From: Sarah Burrow <Sarah.Burrow@arun.gov.uk>
Sent: 19 January 2022 13:11
To: Planning.Responses <Planning.Responses@arun.gov.uk>
Cc: Simon Davis <Simon.Davis@arun.gov.uk>; Paul Cann <Paul.Cann@arun.gov.uk>
Subject: RE: Planning Consultation on: BR/267/21/PL

Engineers Comments Regarding Surface Water Drainage

Application No: BR/267/21/PL

Site Address: Former Westside Supplies Unit West of 17 to 18 Durban Road Bognor Regis
PO22 9QT

ROOF PLAN

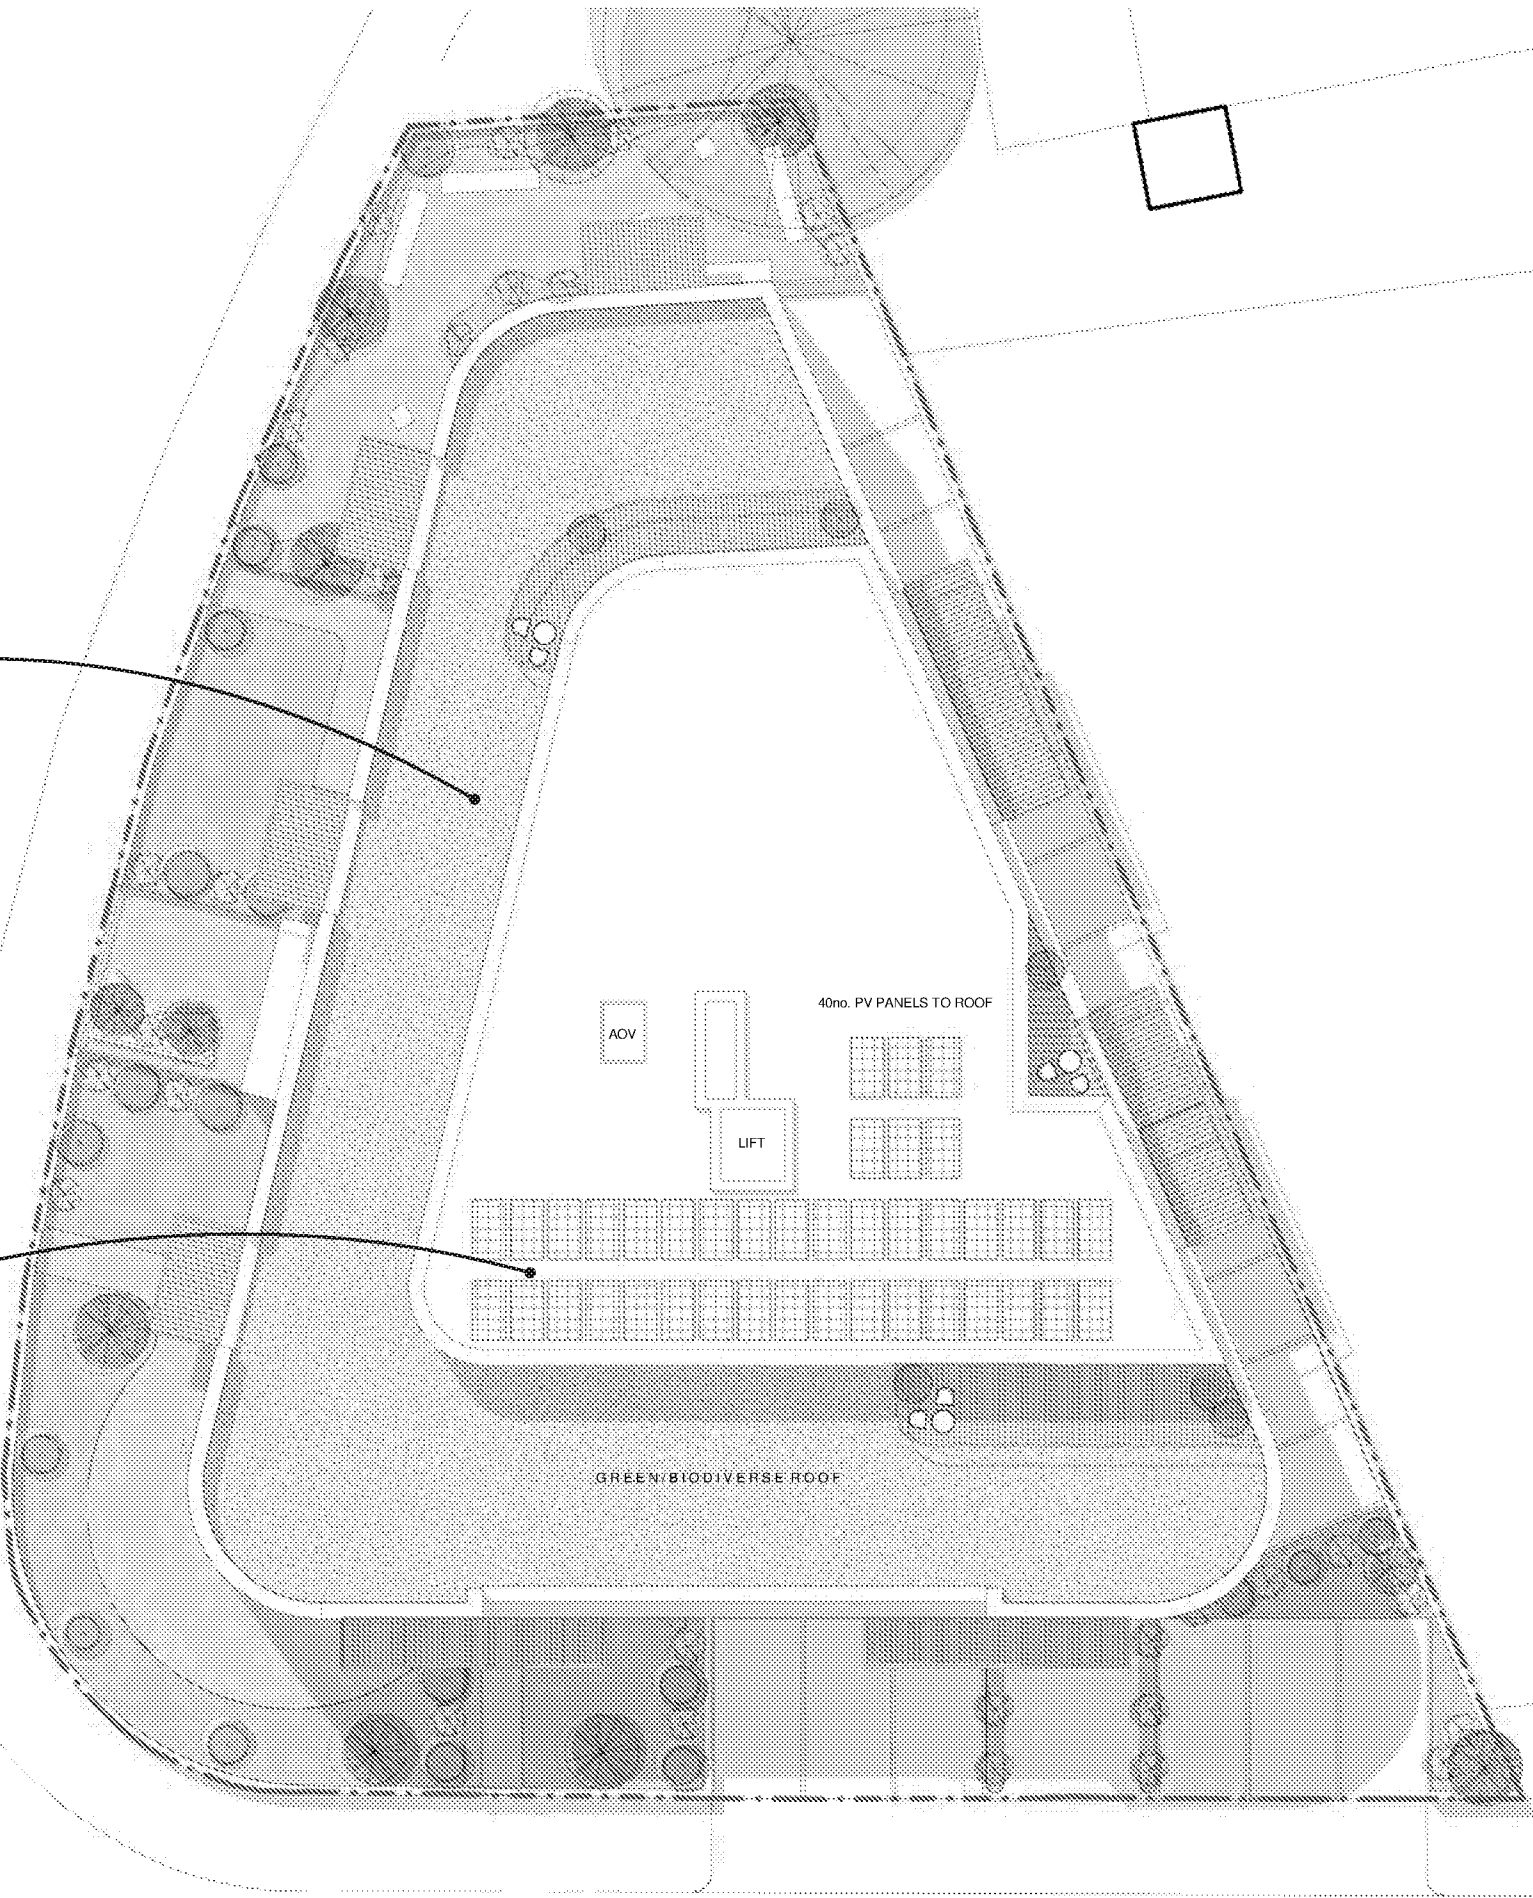
The site is located in Flood Zone 3, the FRA contains a sequential and exception test. These have not been assessed but should be considered by the Planning Officer. The EA should be consulted.

Infiltration has been discounted as an option for disposing of surface water yet it has not been investigated on site, no site specific groundwater monitoring has been supplied. Infiltration must be investigated for surface water disposal. It is advised that the applicant contacts this department as soon as possible to discuss and agree the level of site investigation that is required.

If soakaways are viable they will need to be located at least 5m from the basement. A hybrid solution, whereby some infiltration is allowed and there is an overflow to the watercourse or surface water sewer, will not be possible here.

It is proposed that ground on the site is raised by up to 900mm to raise finished floor levels and reduce risk of flooding to the properties. Ground raising is discouraged. If it is considered absolutely necessary, then due consideration must be given to the potential impacts on existing properties adjacent the development site, in terms of possible elevated groundwater levels and surface water run-off implications. The risk of surface water flooding at the perimeter of the site should also be considered in this instance, as well as the fluvial risk.

“Development shall not commence, other than works of site survey and investigation, until full details of the proposed surface water drainage scheme have been submitted to and approved in writing by the Local Planning Authority. The design should follow the hierarchy of preference for different types of surface water drainage disposal systems as set out in Approved Document H of the Building Regulations, and the recommendations of the SuDS Manual produced by CIRIA. Winter groundwater monitoring to establish highest annual ground water levels and winter Percolation testing to BRE 365, or similar approved, will be required to support the design of any Infiltration drainage. No building / No part of the extended building shall be occupied until the complete surface water drainage system serving the property has been implemented in accordance with the agreed details and the details so agreed shall be maintained in good working order in perpetuity.”
